**MAJOR PROJECT ASSESSMENT:
7-9 Gibbons Street, Redfern
(MP08_0112 MOD3)**

Director-General's
Environmental Assessment Report
Section 75W of the
Environmental Planning and Assessment Act 1979

October 2012

01 WILLIAM LANE ELEVATION  
1:200

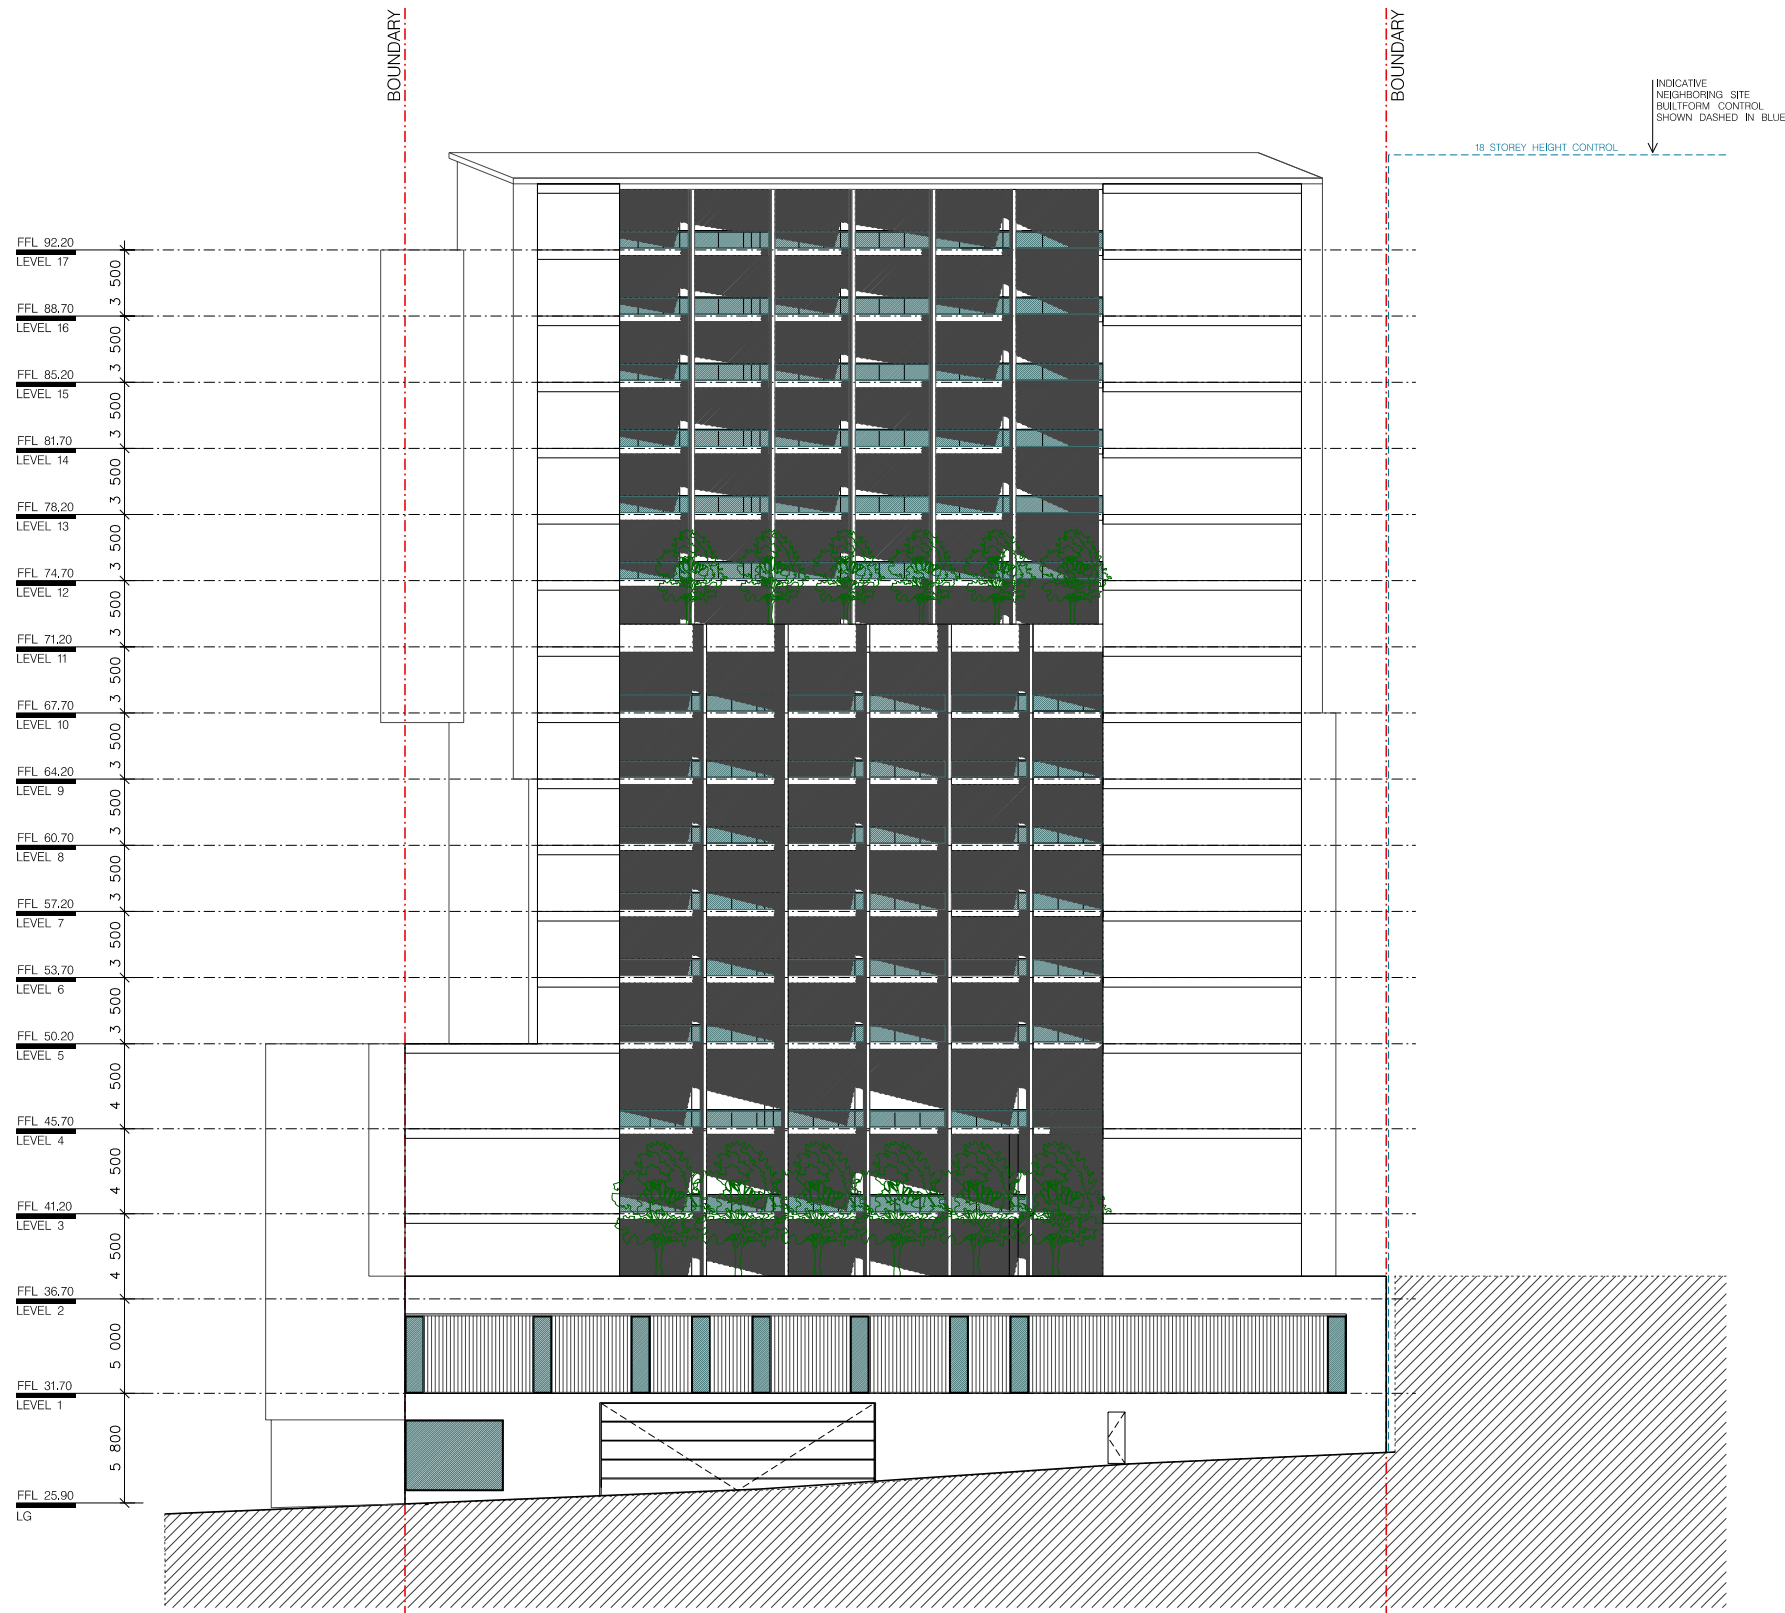
Council's submission raised some concerns with the proposed modification. In particular further consideration of the bicycle parking provisions, access for residential occupants independent of the commercial access and design excellence was requested. Council raised concerns with the location of the proposed external plant room due to potential noise and architectural design, noting the residential properties adjoining William Lane. Issues raised in the submission have been addressed in the assessment section below.

The external appearance remains largely unchanged. Initial concerns were raised in relation to the external plant due to visual impacts and consistency with the *Residential Flat Design Code*. This concern was also raised in the City of Sydney Council submission. In response, the proponent submitted amended plans which relocated the plant area within the internal envelope of the building.

The City of Sydney Council has raised concern in relation to the modifications and requested that the additional proposed plant on William Lane be given consideration with respect to environmental compliance and amenity perspective. Subsequently, the Department requested that this external plant be deleted and relocated within the internal building envelope, which has been accomplished in amended plans.

As a consequence of this concern, the plant has been relocated to Level 01 (High Level), which substantially reduces the potential acoustic impacts to residents within the building at 157 Redfern Street and those within the subject building. In this new location, the plant would be located adjacent to void areas and stair wells as opposed to a residential unit.

DRAWING:
LEVEL 18 +
ROOF PLANS
DRAWING No.:
DA - 1106
ISSUE
C

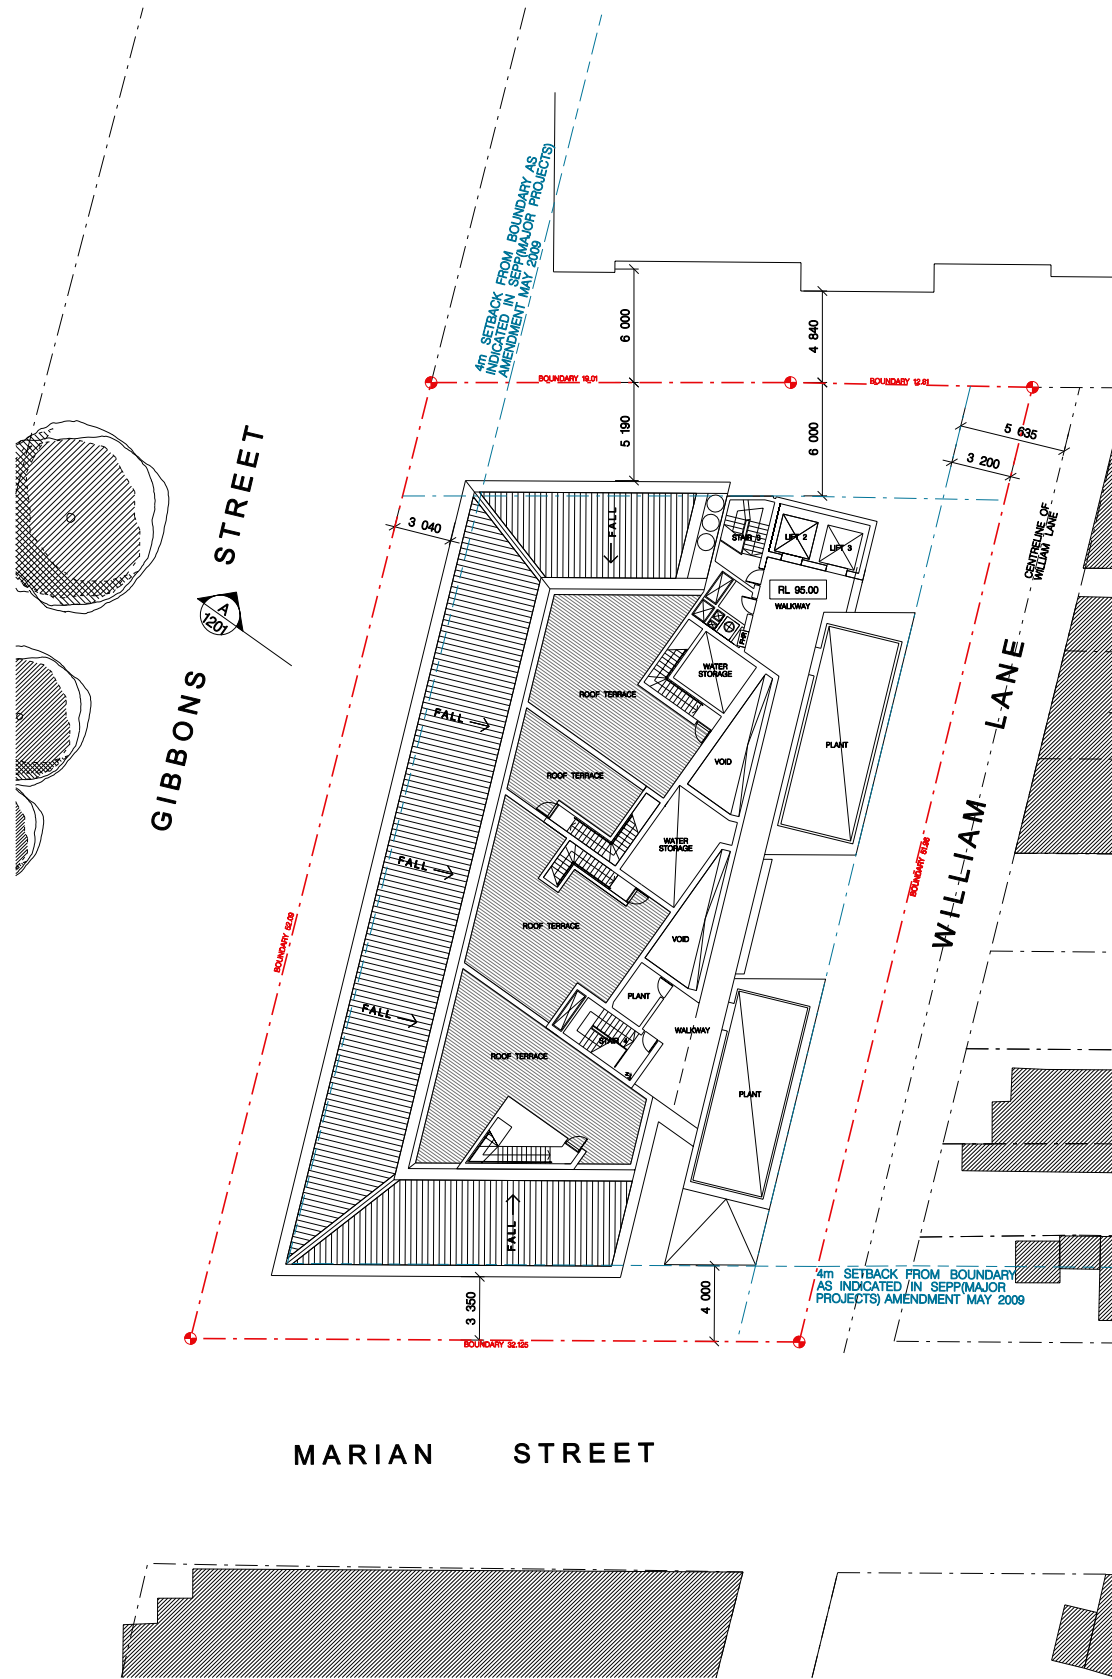
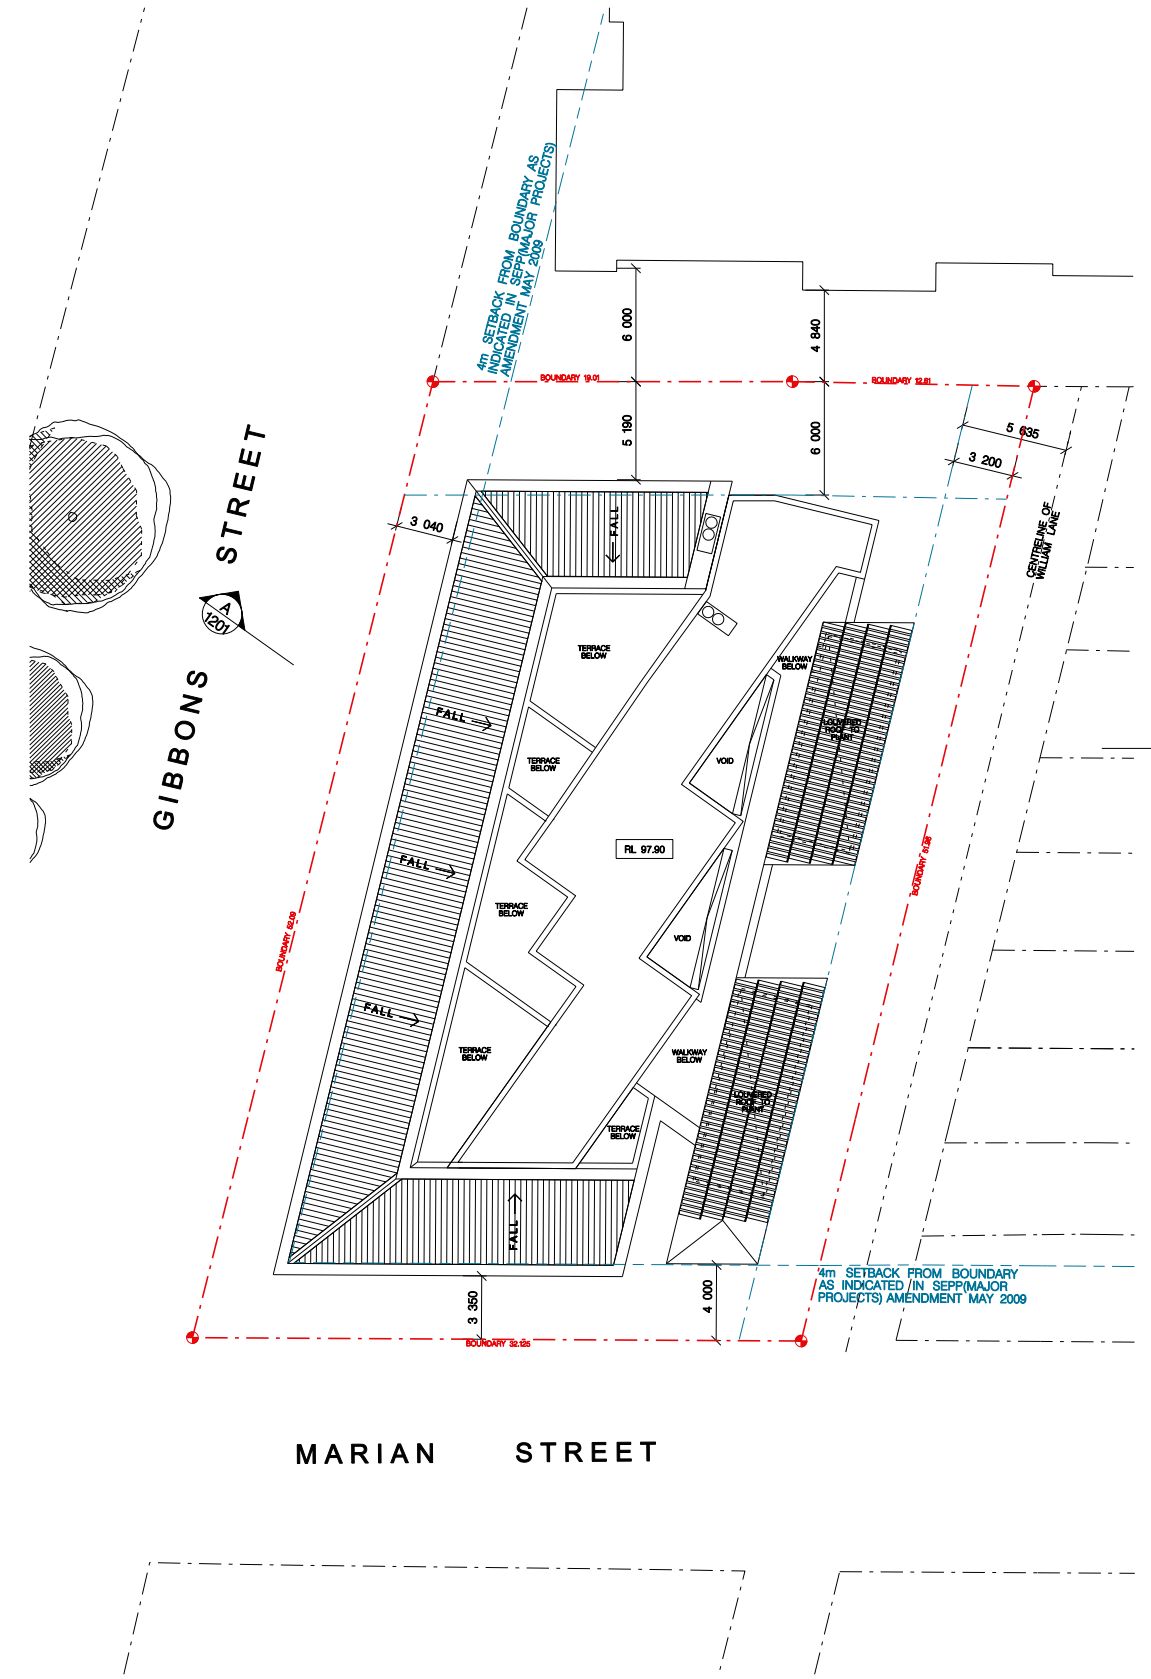
There are modifications to the roof to extend the slabs over the stair cores and add louvered plant screens to the perimeter. The proposed roof amendments do not exceed the maximum approved height of 98 metres. The current proposed height is 95.5 metres and the additional roof extensions are below this height. The roof modifications do not result in any significant adverse impact upon the design quality or visual appearance of the building. The maximum building height is not breached as a result of the modifications and the plant screens aid in limiting potential adverse visual impacts.
